Your Reference: MP10\_0168  
Our Reference: SYD10/00893  
Contact: Stella Qu  
Telephone: 8849 2520

**EXHIBITION OF ENVIRONMENTAL ASSESSMENT FOR MIXED COMMERCIAL  
AND RETAIL DEVELOPMENT (STAGE 1) AT 2 AUSTRALIA AVENUE, SYDNEY  
OLYMPIC PARK**

Chris Goudanas  
**Chairman, Sydney Regional Development Advisory Committee**  
19 December 2011

scale
 1:400 @ A3
 0m 4 8 12 16

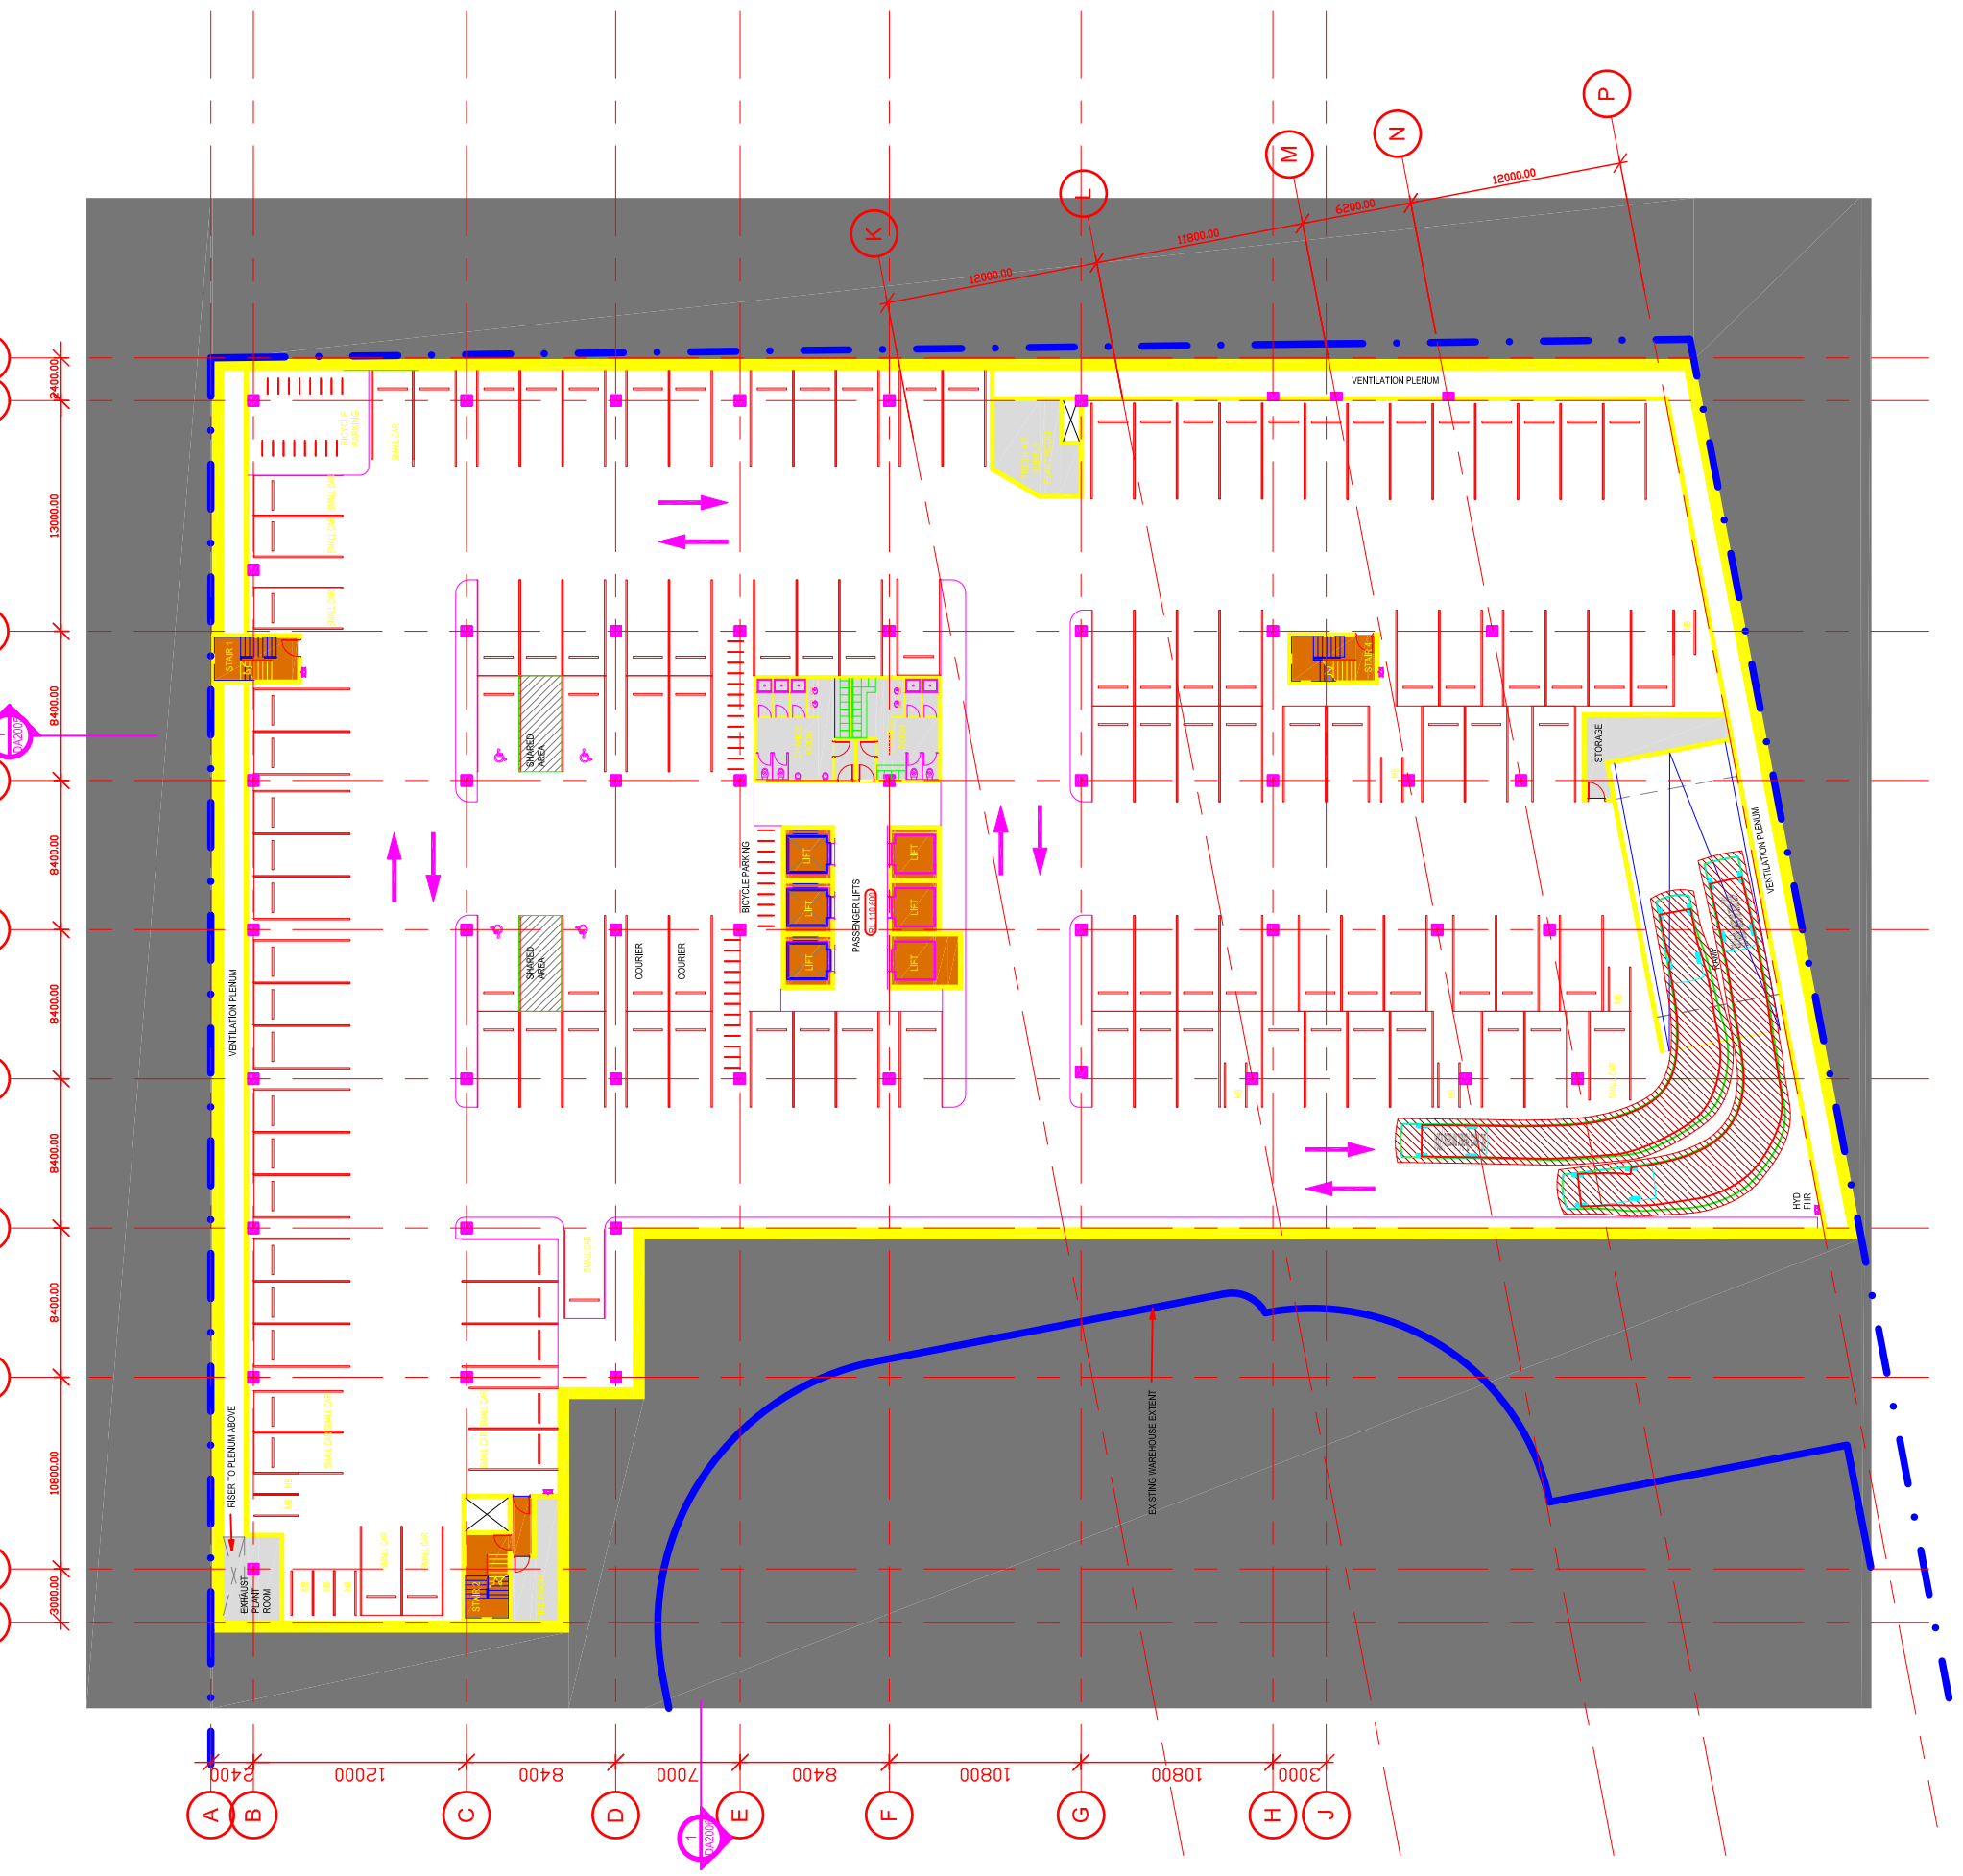
2. The swept path of the longest vehicle entering and exiting the subject site, as well as manoeuvrability through the site, shall be in accordance with AUSTROADS. It is noted that the nominated longest vehicle permitted to enter the site is 8.8 metre medium rigid vehicle (MRV). The DP&I shall be satisfied that the proposed commercial and retail land use will not be serviced by vehicles larger than 8.8 metres in length.
3. The number of car parking spaces shall be provided to the satisfaction of the Department of Planning & Infrastructure (DP&I) and Transport for NSW.
